Application for Planning Permission for Works or Extension to a Dwelling

Development: Demolition of existing single detached garage and construction of new utility/pool room and new single side garage. (This application may affect the character and appearance of the Aldwick Bay Conservation Area).
Location: 226 Manor Way Aldwick PO21 4HS

Location Plan
Scale 1 : 1250

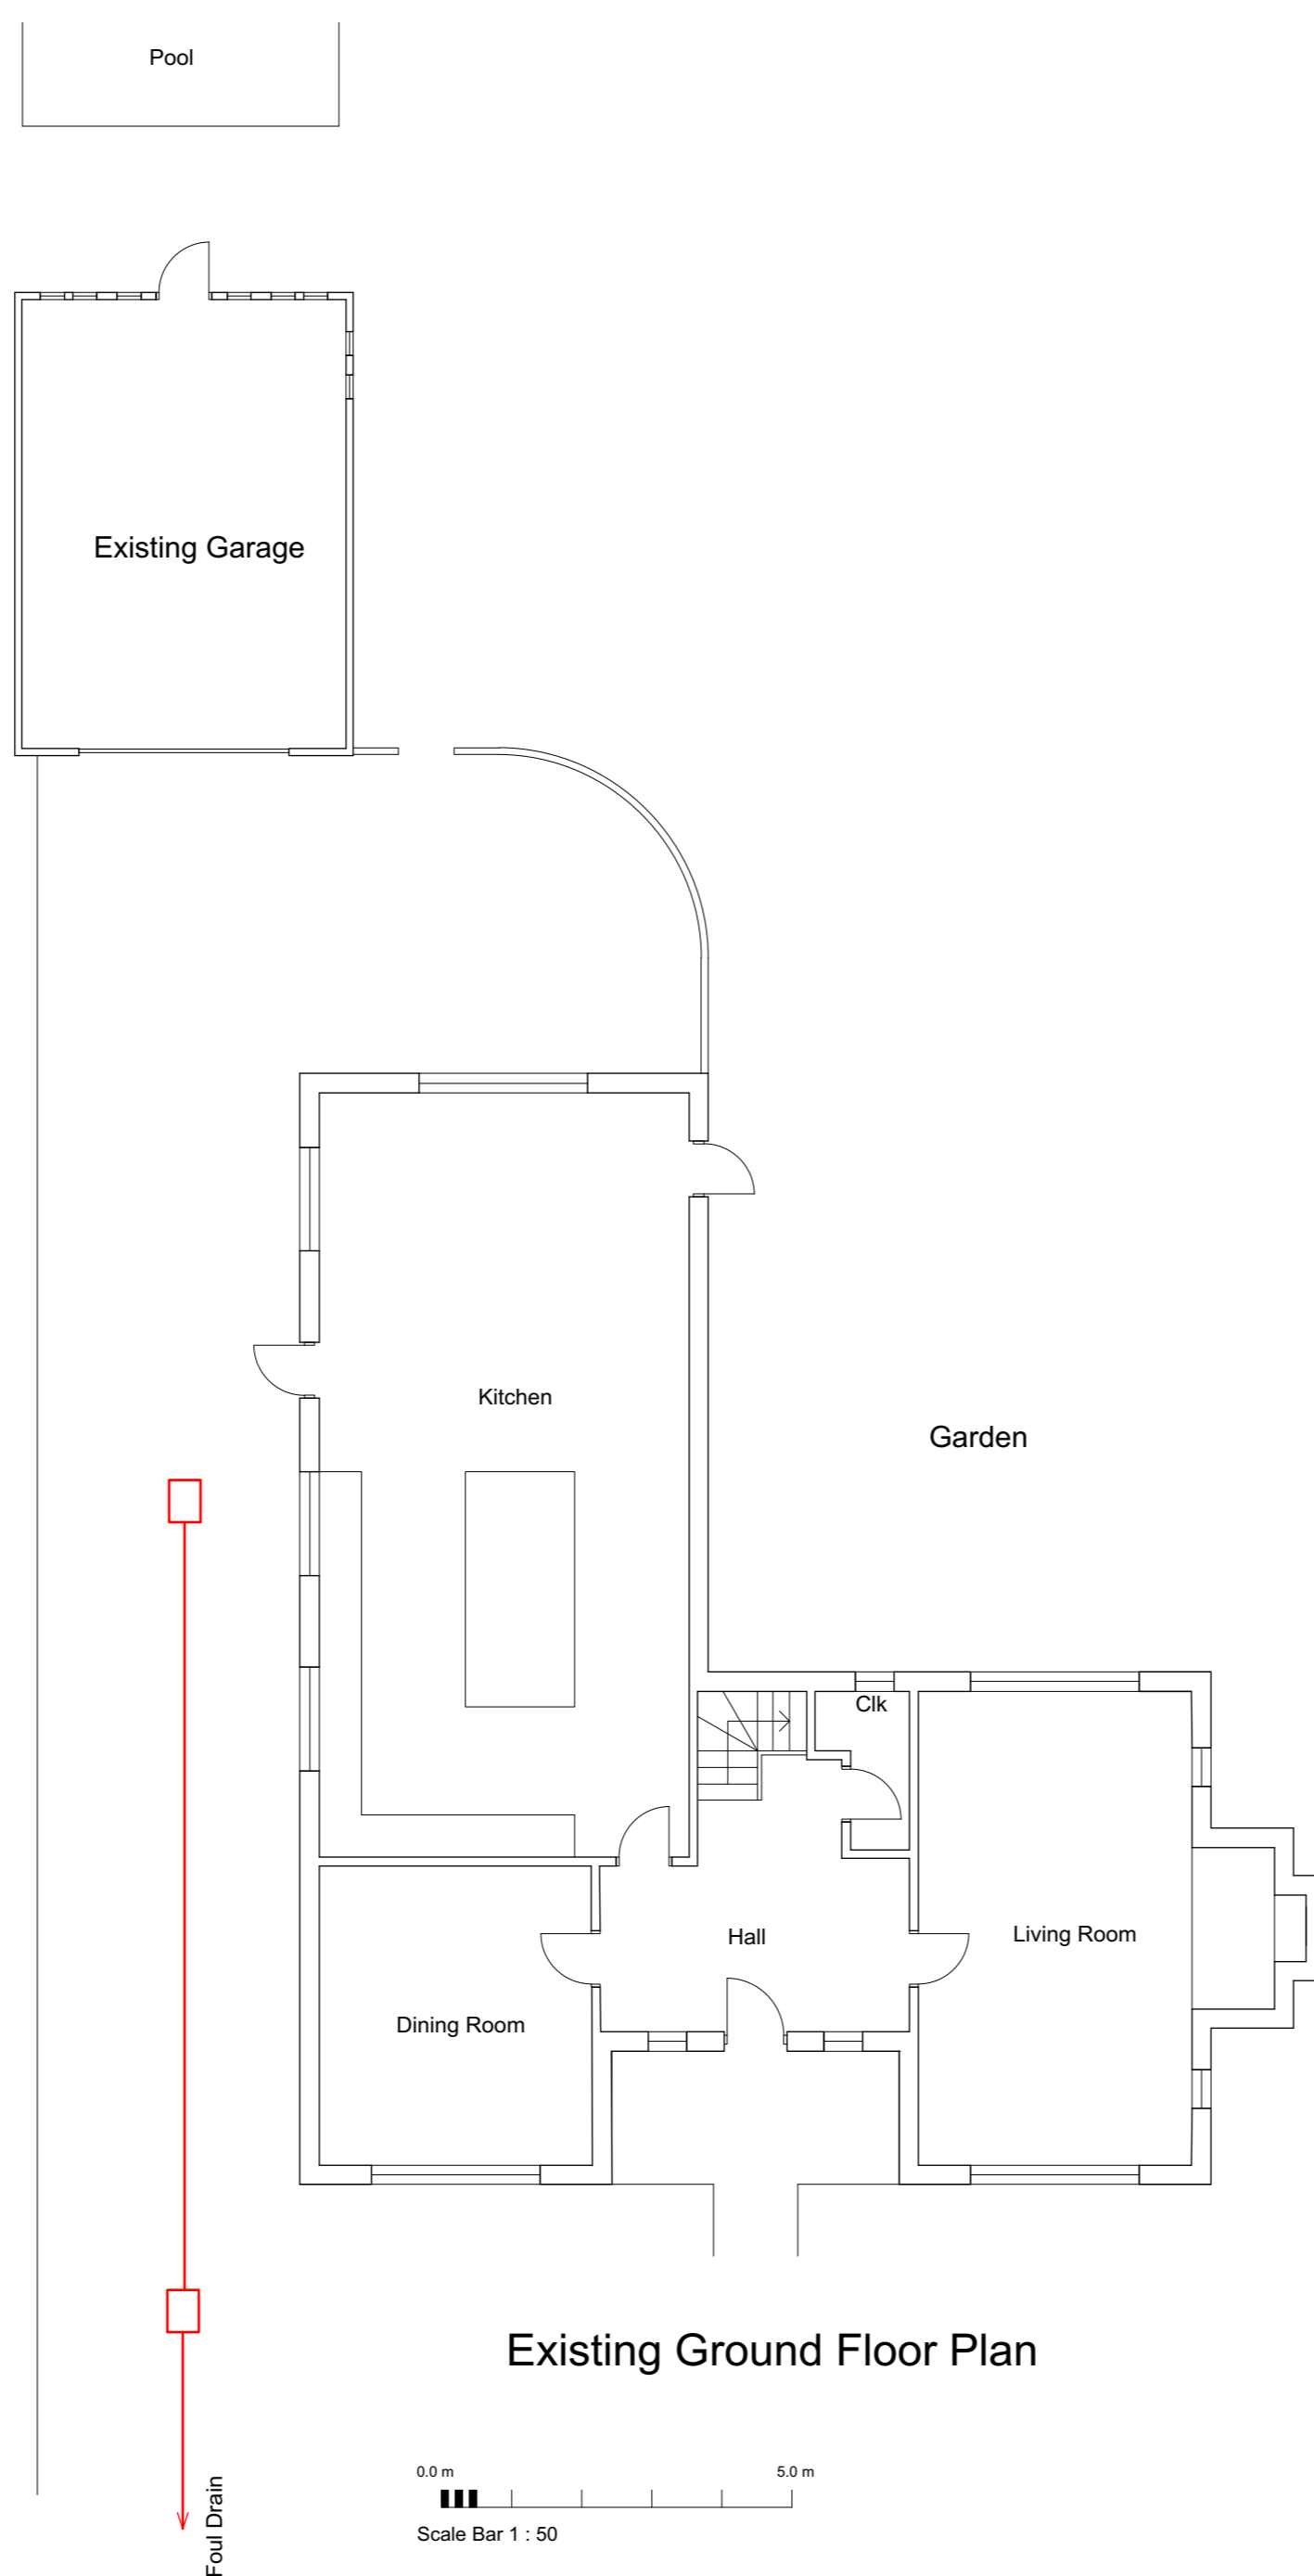
The scale bar included with the Location Plan is 1:500, when the drawing is labelled as 1:1250.

Please review and amend these drawings.

PROJECT	226 Manor Way	DATE	15/10/25
TITLE	Plans	DRG NO	IBA/613/01
SCALE	As Noted	REVISIONS

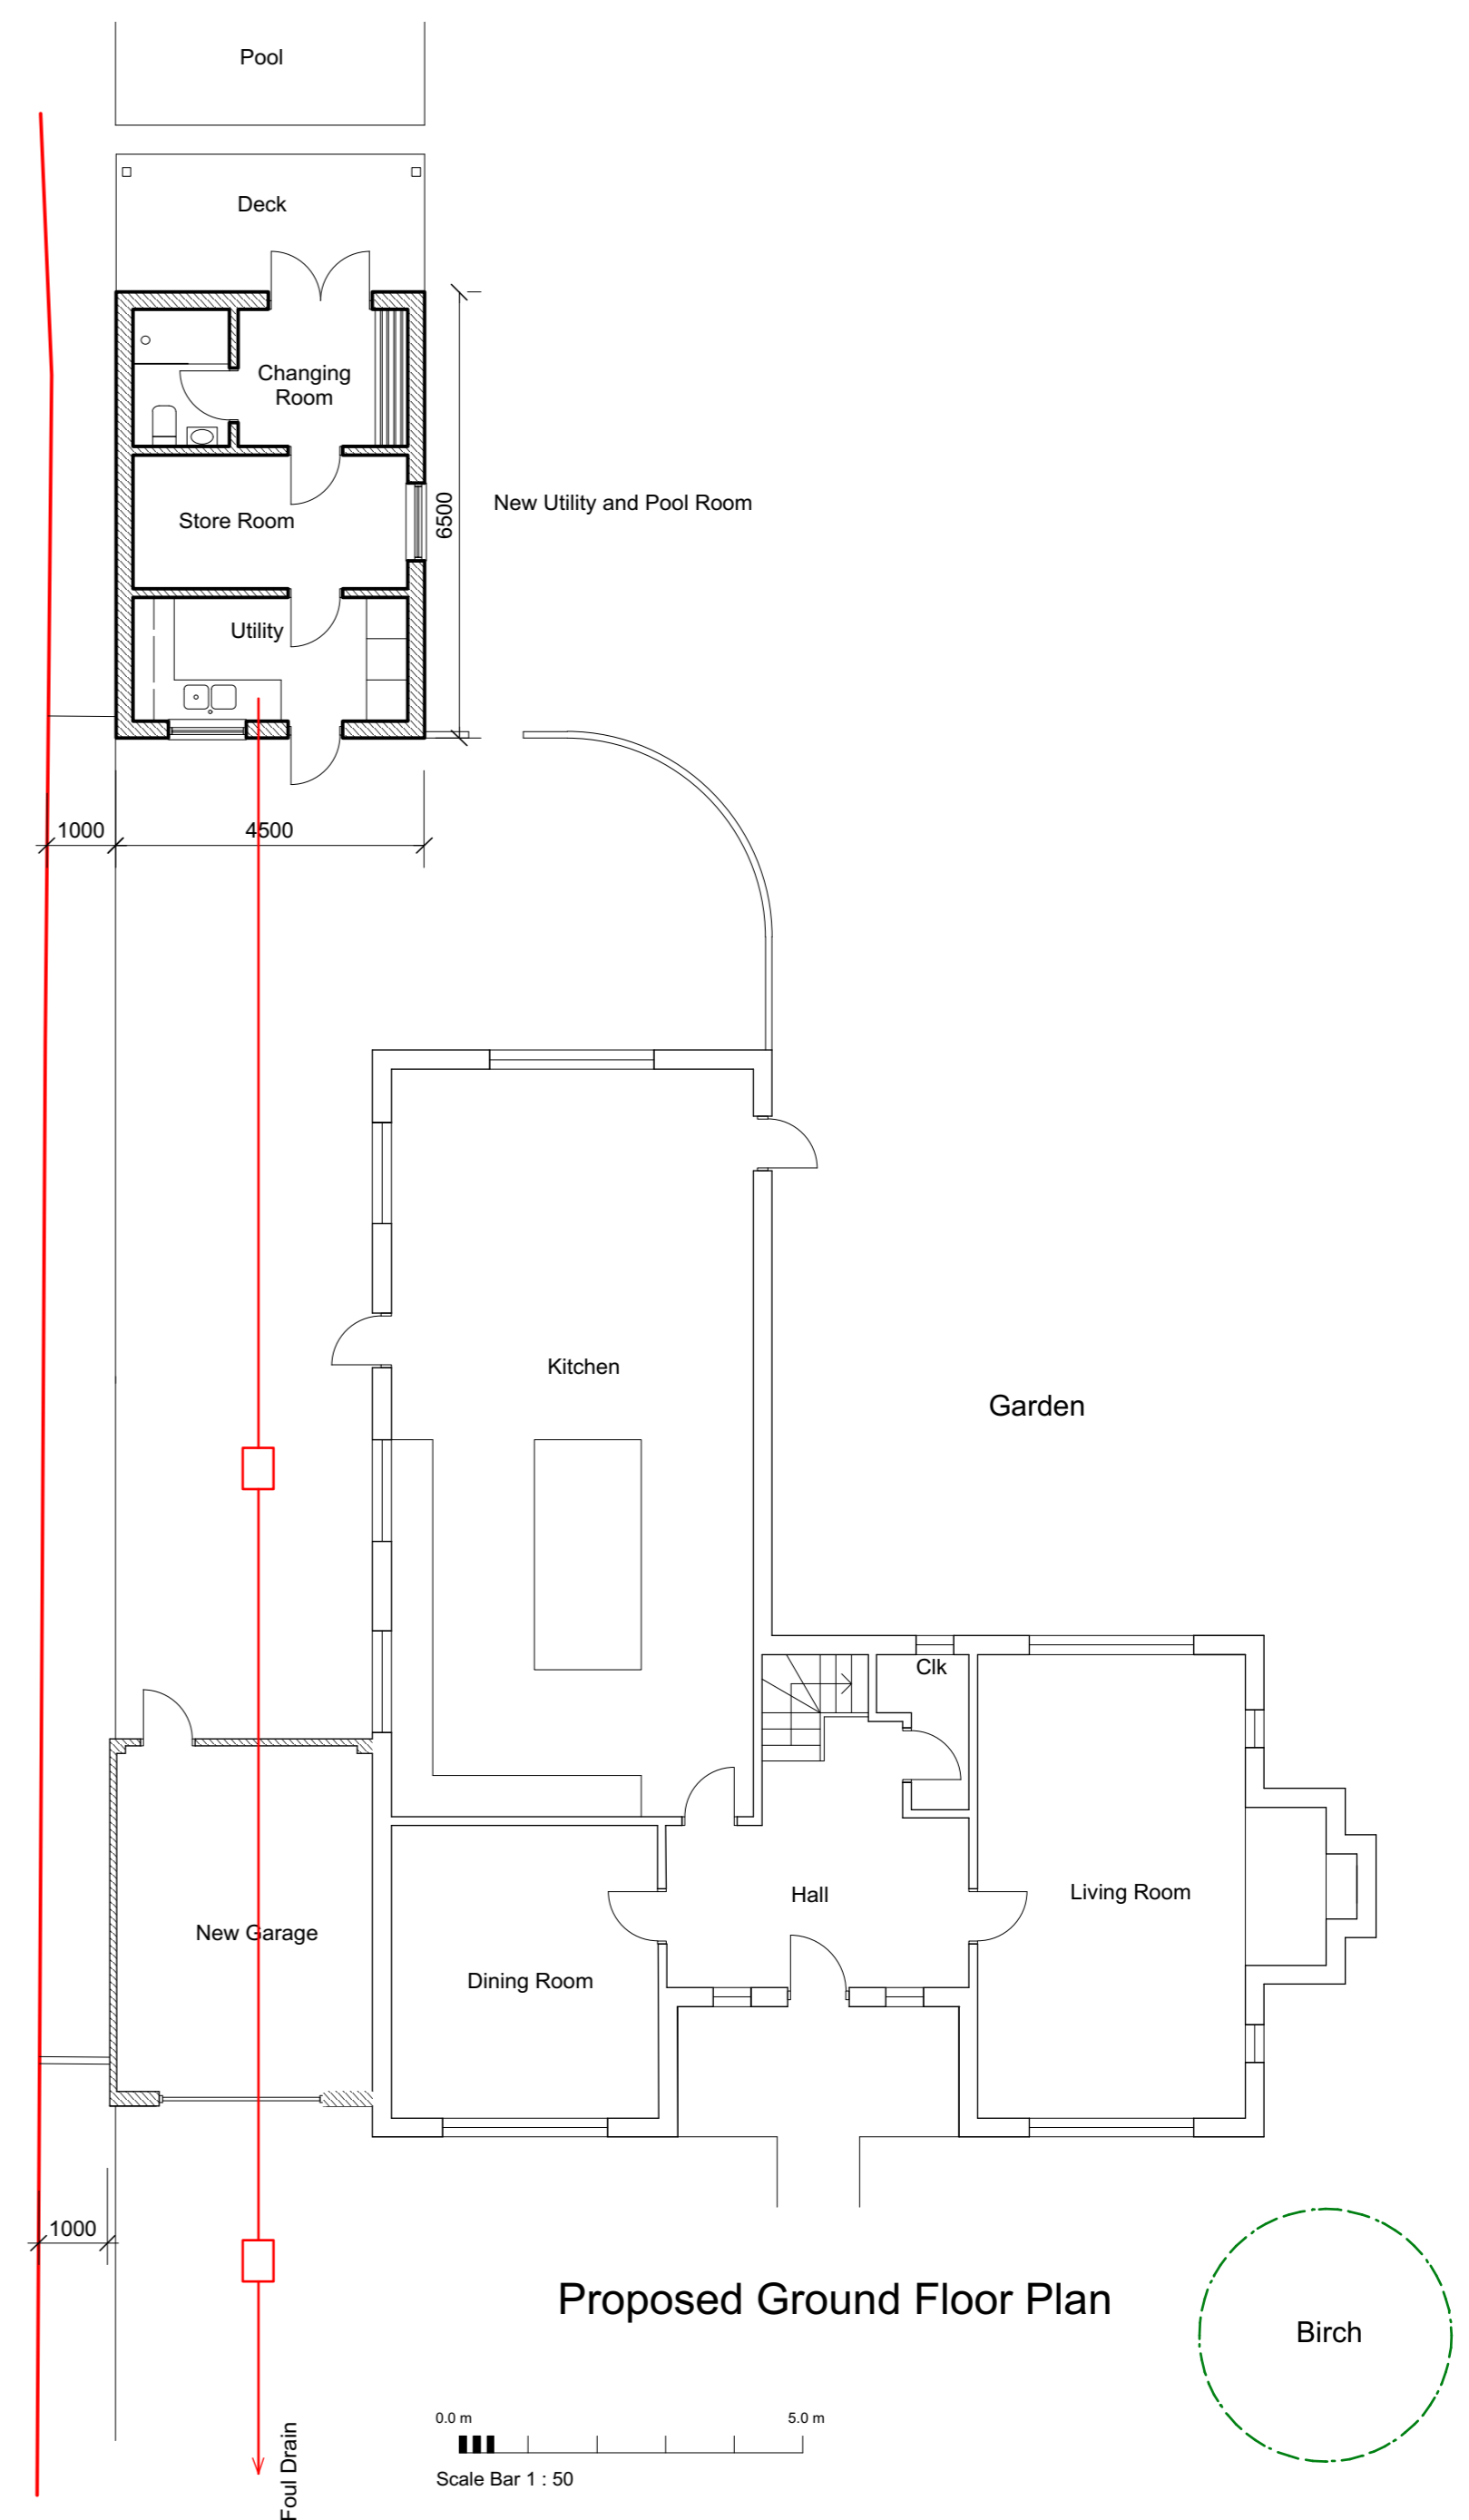
There is also no scale bar provided for the existing plans (Drawing 01- stated as 1:100), the roof plans/garage elevations (Drawing 03- stated as 1:100), and for the utility room elevations and plans (Drawing 04- stated as 1:50).
